CITY OF ALBUQUERQUE

November 7, 2022

Re: G.A.A.R. Building Renovation
1635 University Blvd. NE
Traffic Circulation Layout
Architect's Stamp 05-20-22 (H15-D008)

A1 TRAFFIC PLAN  
1" = 40'-0"

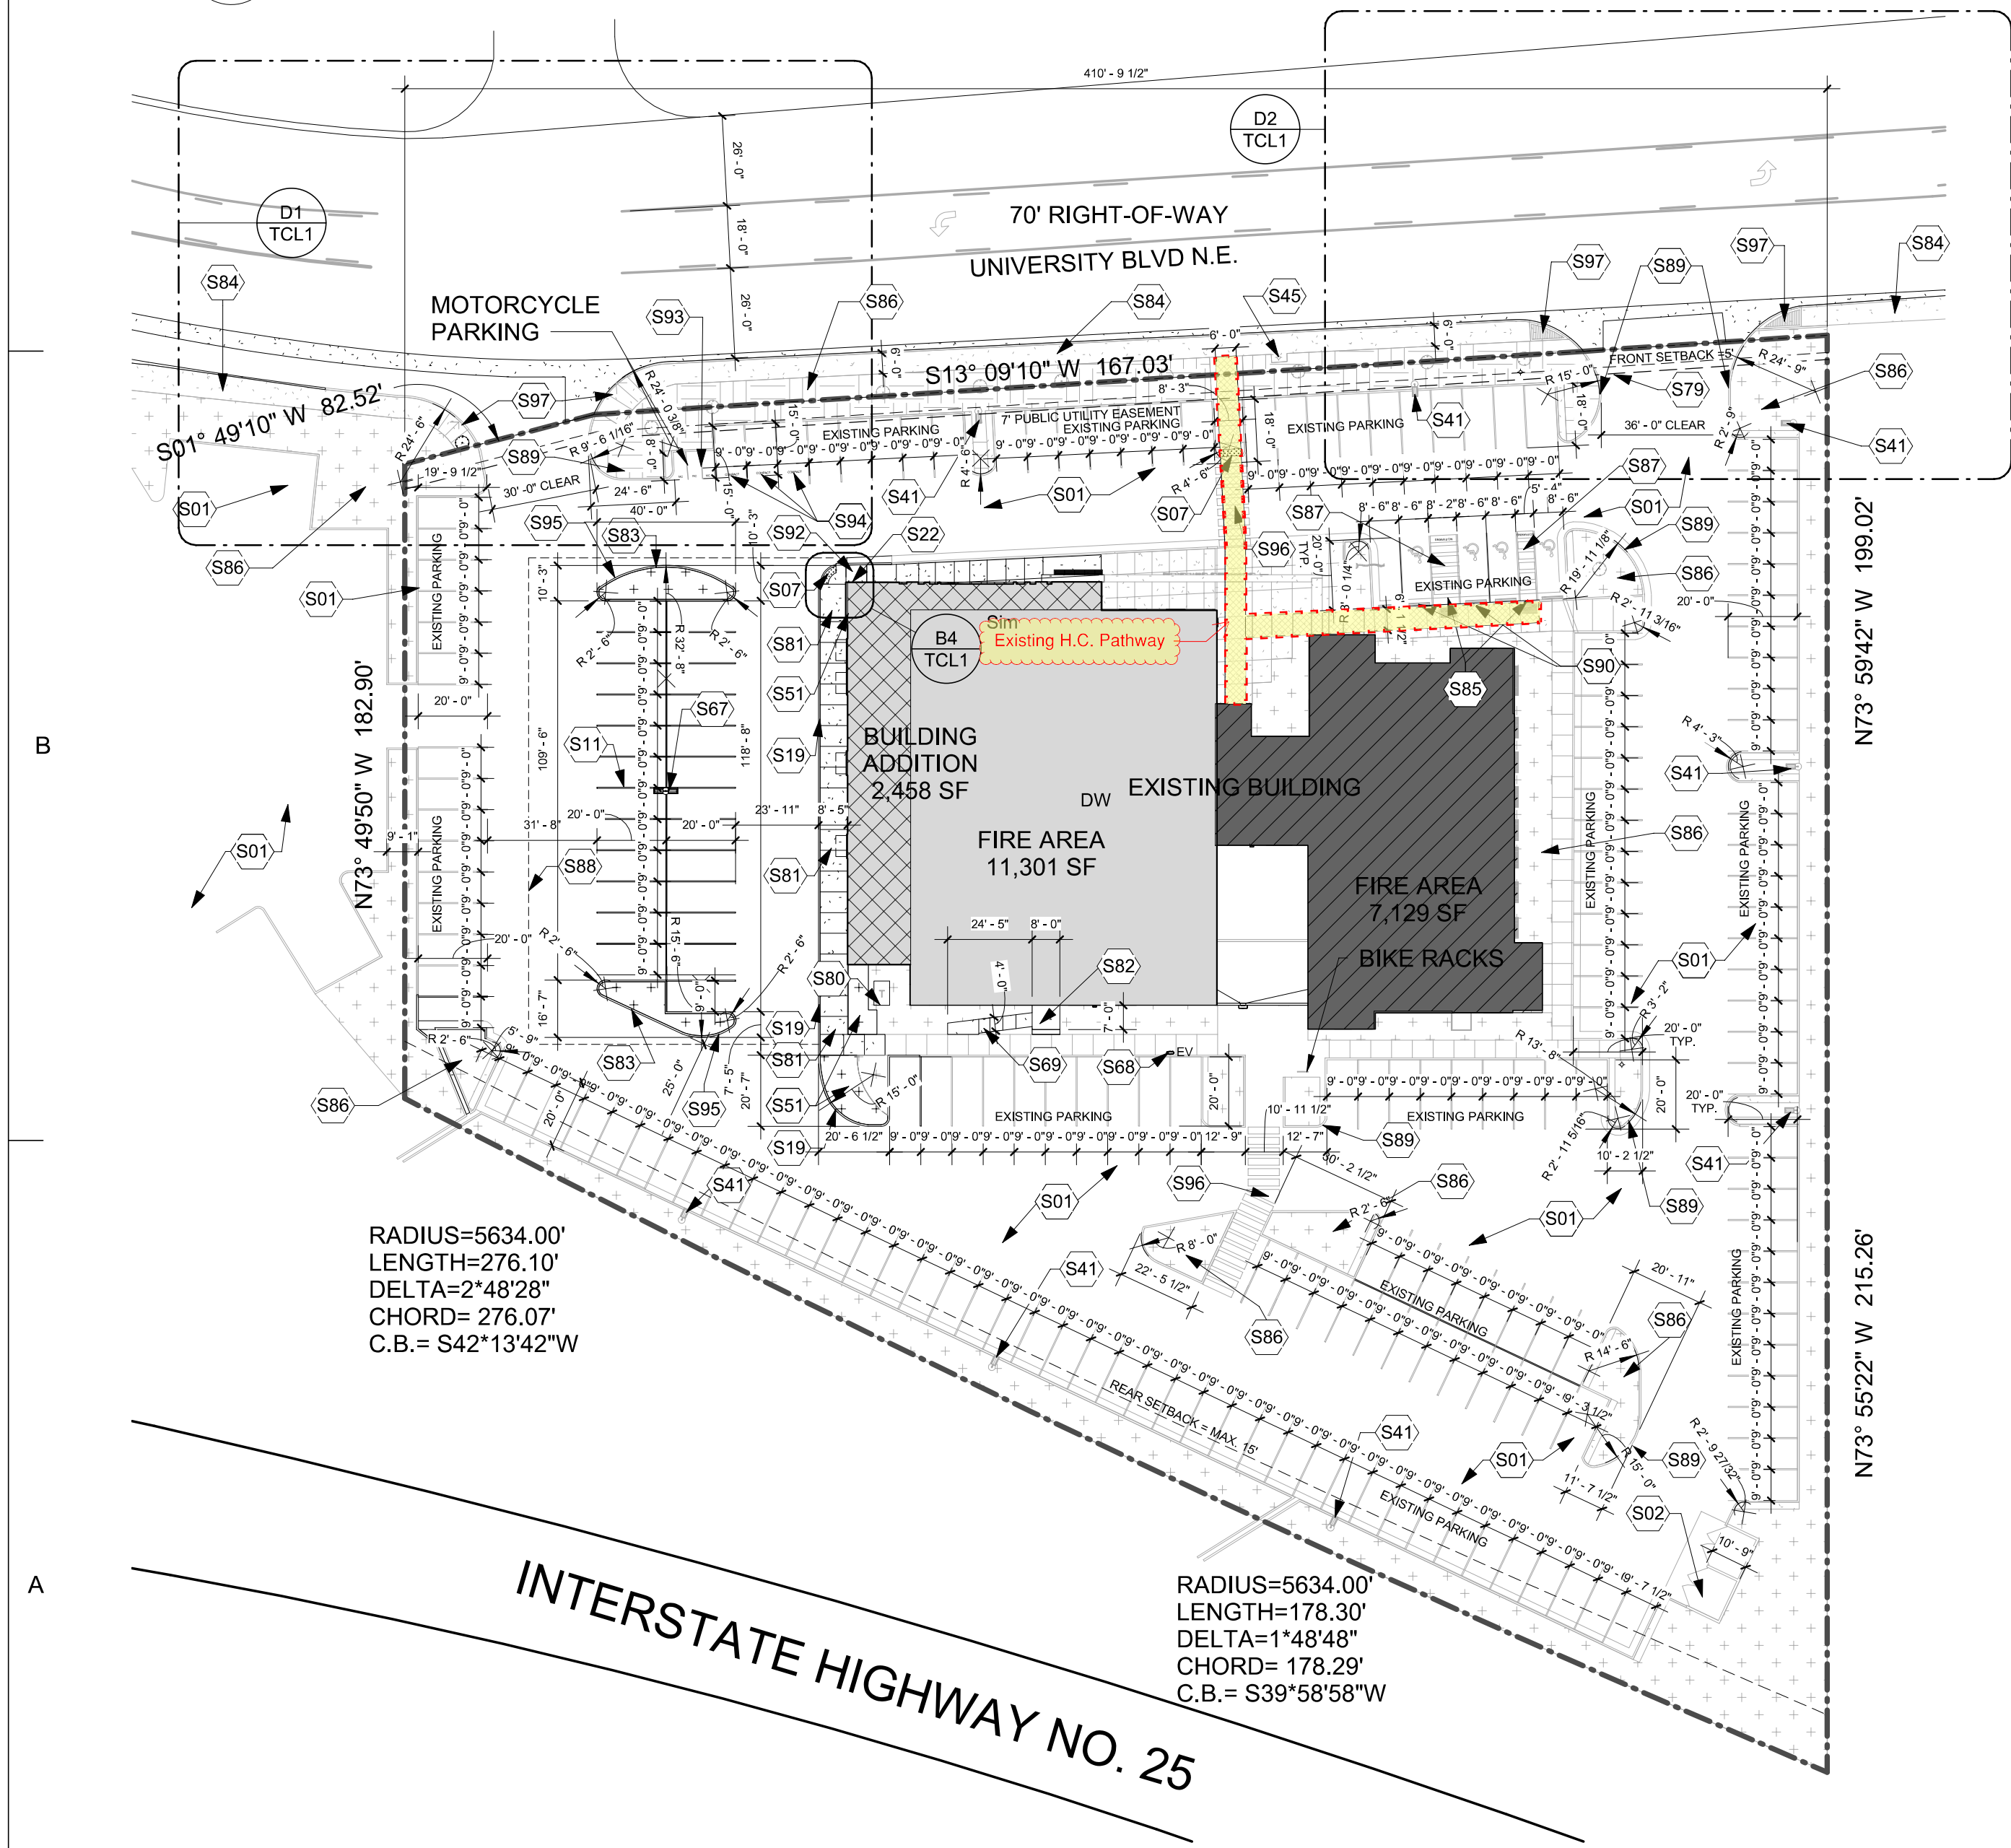
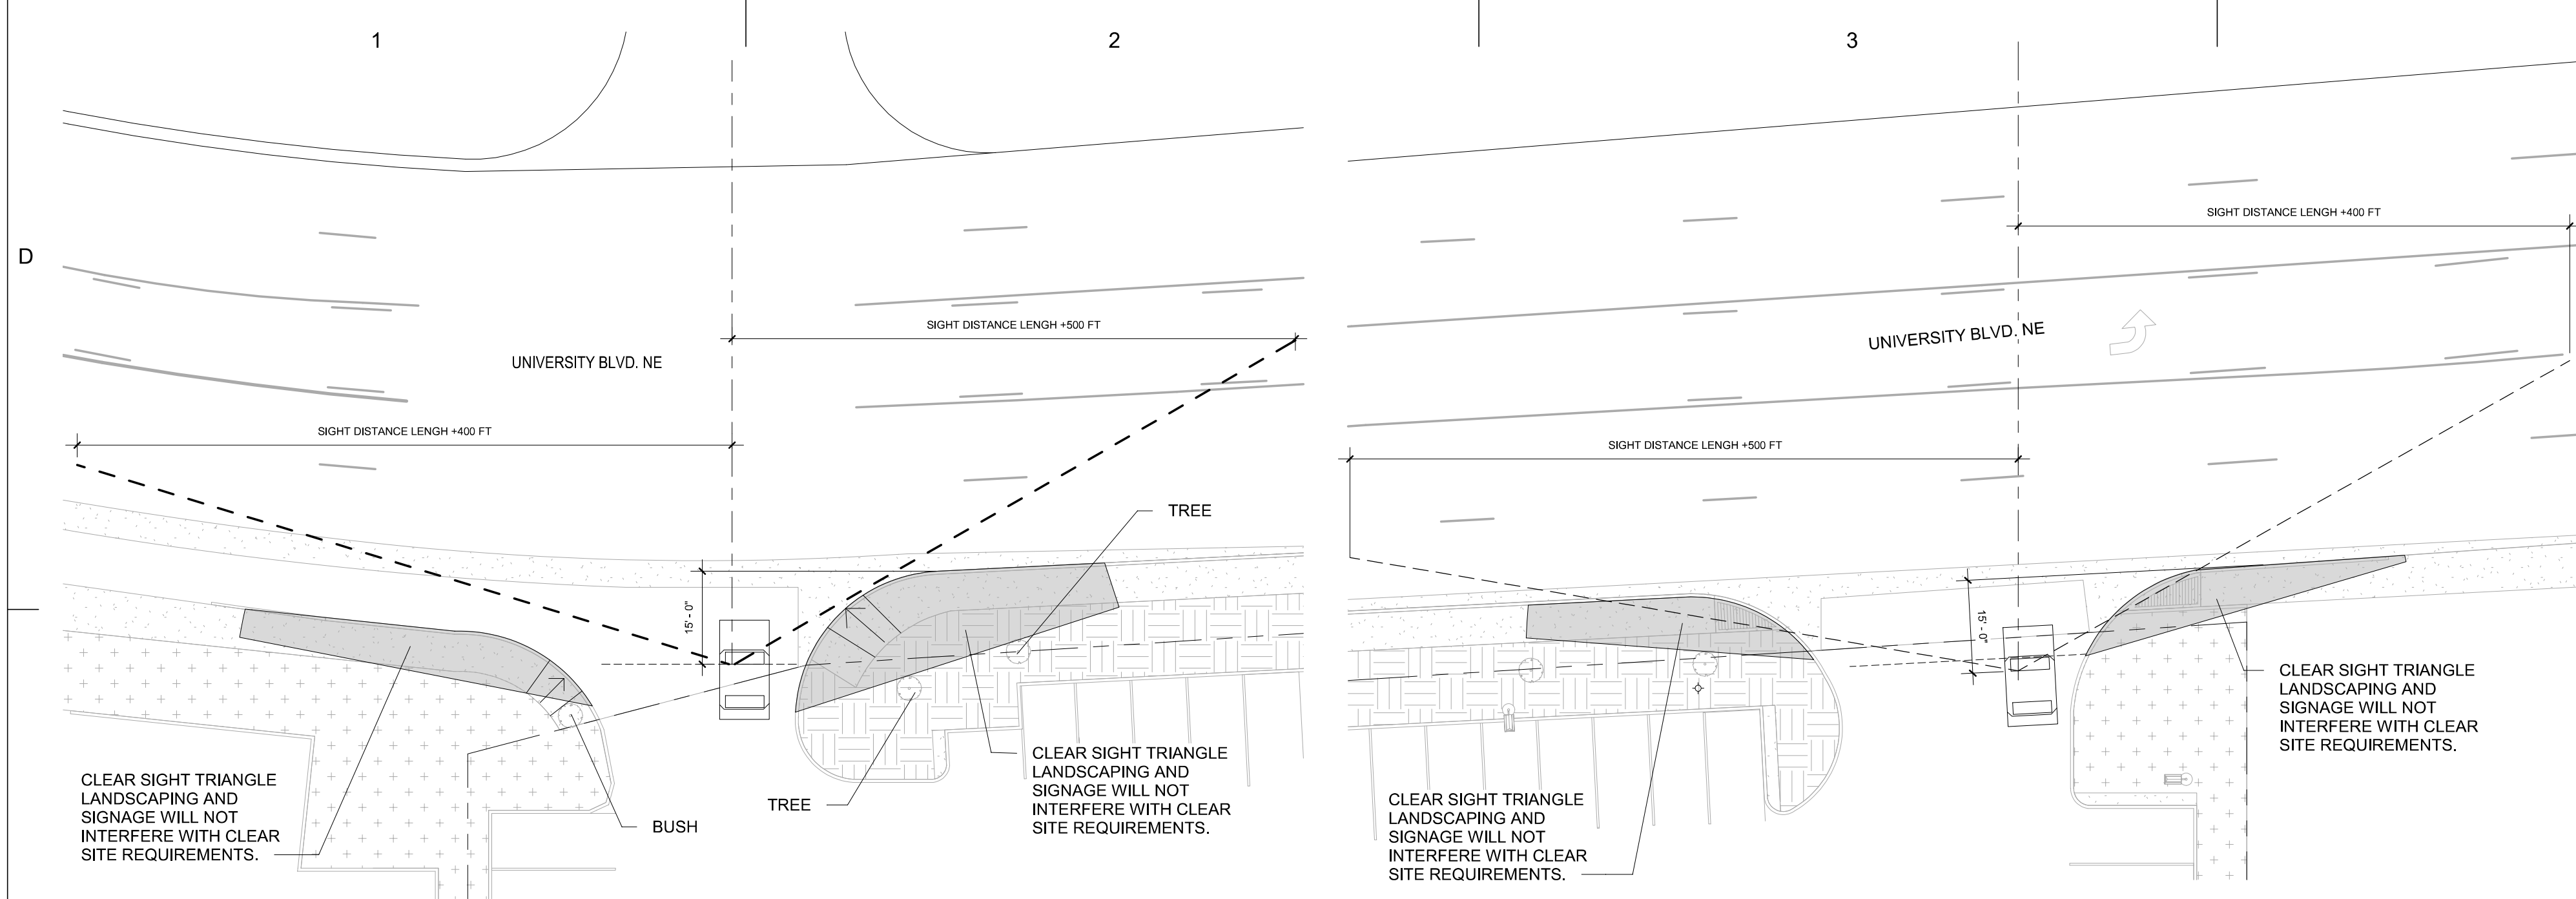
1. Label the compact parking spaces by placing the words "**COMPACT**" on the pavement of each space.
2. Key note S01: the aerial shows the parking spaces striping is fading. I'd like to request restripe the parking spaces if applicable.

3. Key note S69: The minimum width for the pathway should be 4 ft.
4. Key note S81: Call out COA std dwg 2430.
5. Key note S82: Please add a note stating that the max. slope for the landing area should be 2% in all direction.

6. Key note S90: Please provide face sign details.
7. Key note S96: Per the IDO, a 6 ft. wide ADA accessible pedestrian pathway is required from the public sidewalk to the building entrances. Please clearly show this pathway and provide details.

8. Key note S97: ADA curb ramps must be updated to current standards and have truncated domes installed.
9. Please provide details for all the interior ADA ramps.

10. Show all drive aisle widths and radii. Some dimensions are not shown.
11. The pavement marking "MC" should be shown in the opposite direction for Motorcycles entering the parking space.

12. Per DPM, a 6 ft. wide ADA accessible pedestrian pathway is required from the ADA parking stall access aisles to the building entrances. Please clearly show this pathway and provide details.

13. ADA accessible pedestrian pathway should not be placed behind parking space or adjacent to a vehicular way. Vehicle and pedestrian/wheel chair conflicts should be avoided as much as possible.
